TERRA RIDGE NORTH CIVIL CONSTRUCTION PLANS El Paso County, Colorado

Prepared By:
Lodestar Engineering, LLC
P.O. Box 88461
Colorado Springs, CO 80908
SEPTEMBER, 2022

EL PASO COUNTY DEVELOPMENT
REPLAT TERRA RIDGE LOTS 5 & 6 W/ 11 LOTS IN
TERRA RIDGE NORTH
COVER SHEET

DETENTION/WATER QUALITY FACILITY
1"=30'

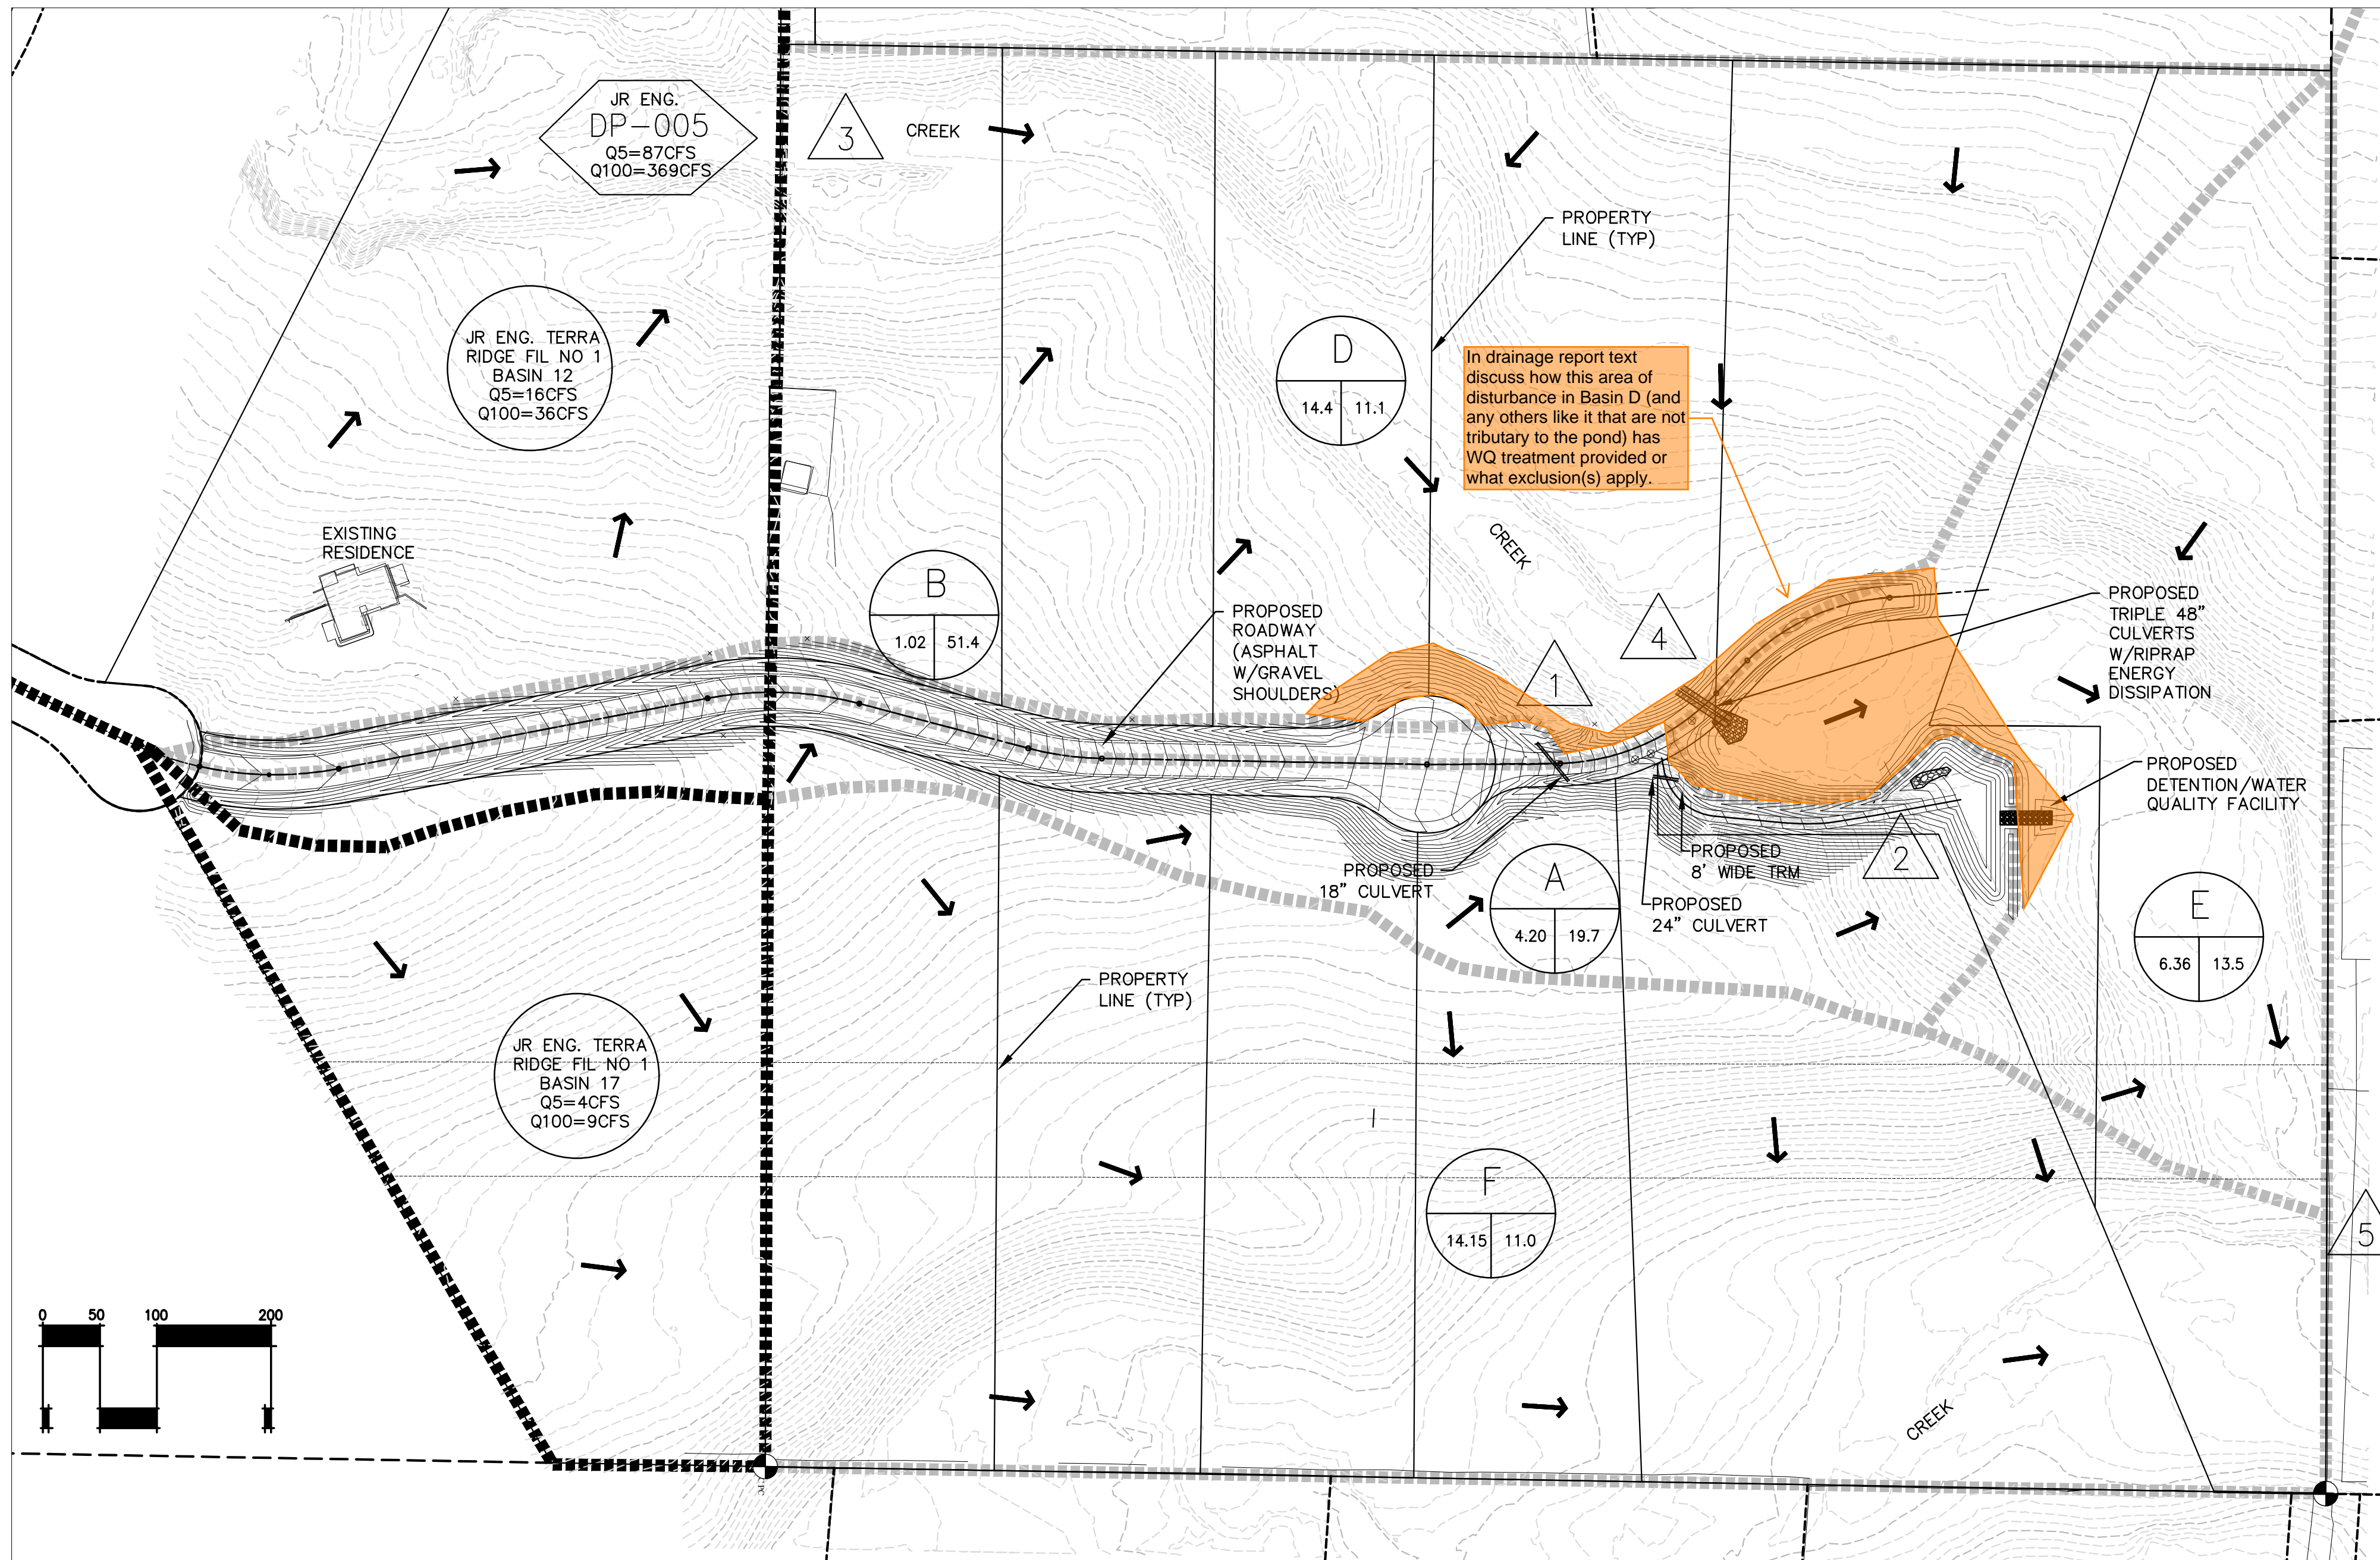
Provide access road detail/cross section, including stone sizing and gradation. Show cross slope at 2%.

Stabilized access ramp shall be a minimum of 15ft wide and no greater than 12% slope, in accordance with DCMV1, Chap 11.2.2.

Pond bottom should have a minimum slope of 3% to the trickle channel and micropool (USDCM Vol 3, detail T-5). Please adjust to minimize future maintenance needs.
